REQUEST

Current Zoning: ML-1 (Manufacturing & Logistics 1), ML-2 (Manufacturing & Logistics 2), and N1-B (Neighborhood 1-B)
Proposed Zoning: I-2 (CD) (General Industrial, Conditional)

Approximately 5.86 acres located on the east side of China Grove Church Road, south of Westinghouse Boulevard, and north of Blu Rail Way.

SUMMARY OF PETITION

SITE PLAN

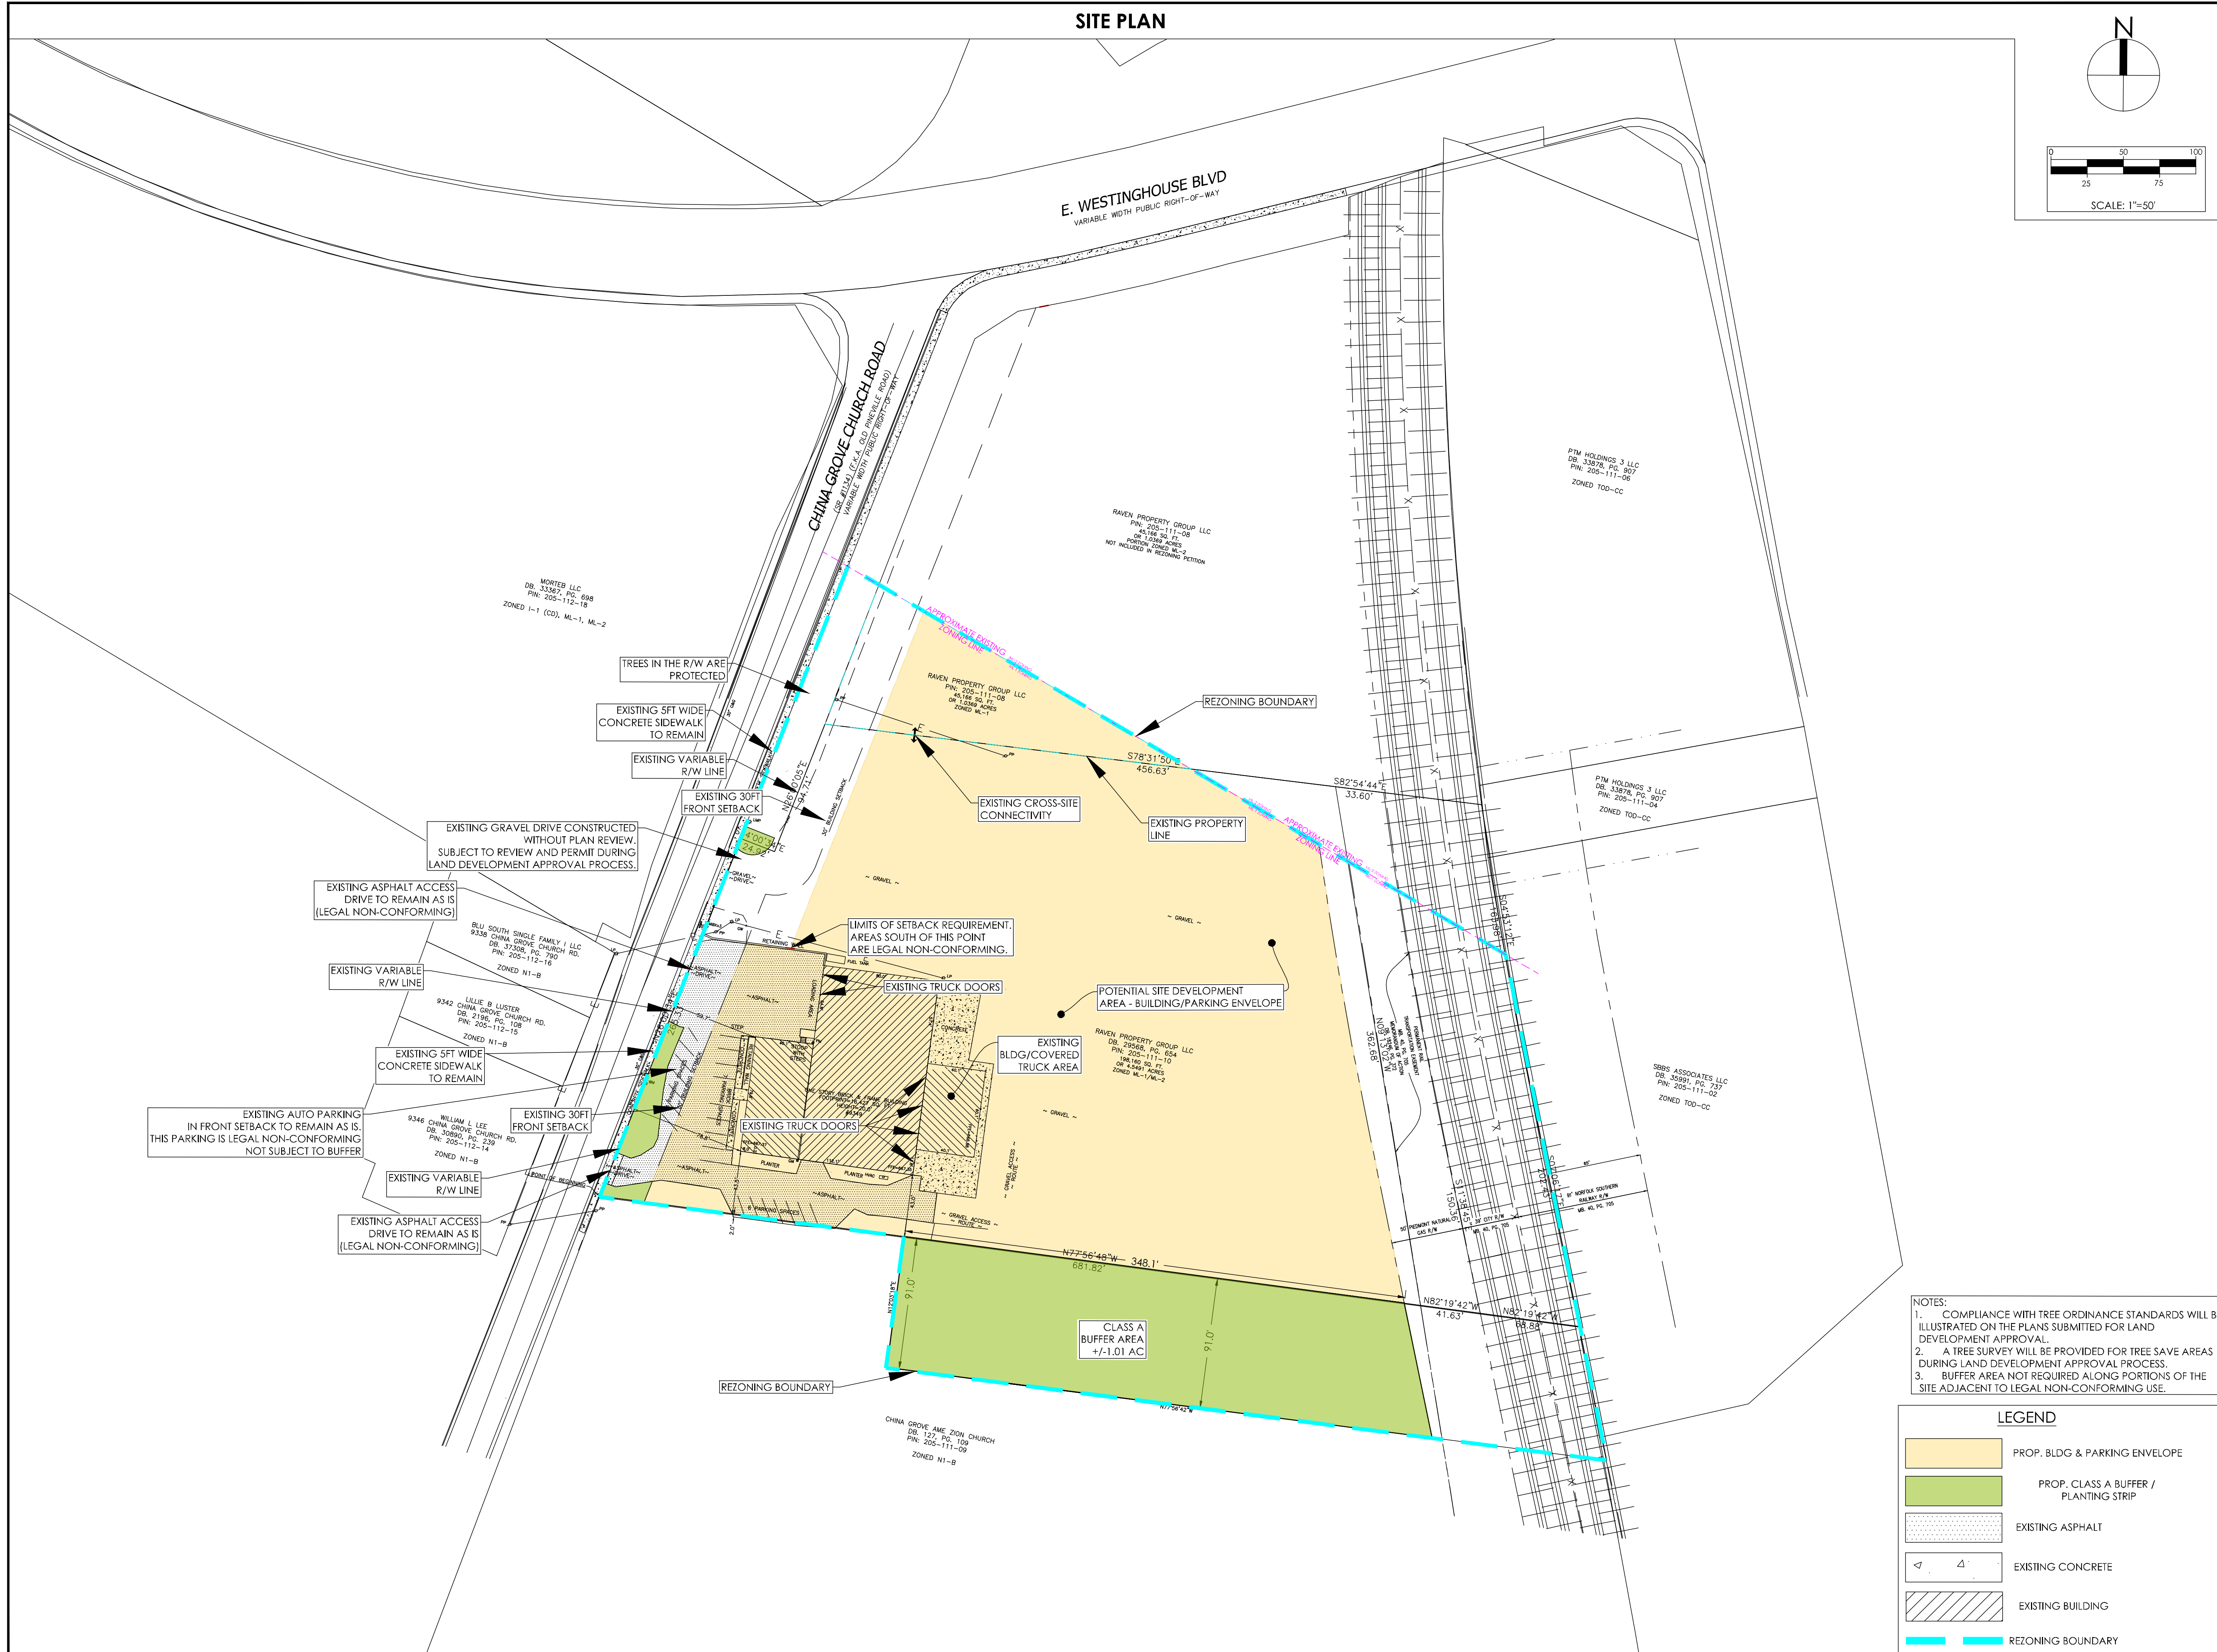
1. Provide a tree survey identifying all trees of eight-inch DBH or greater and all planted trees of two inch caliper or greater and six feet in height that grow partially or wholly within public street right-of-way. The survey shall also identify all trees of eight-inch dbh or greater within the tree protection zone. **OUTSTANDING**
2. Remove parking area and driveway in the southwestern corner of the site and plant buffer. **OUTSTANDING**
3. Illustrate ordinance required screening along China Grove Church Road on the site plan. **OUTSTANDING**
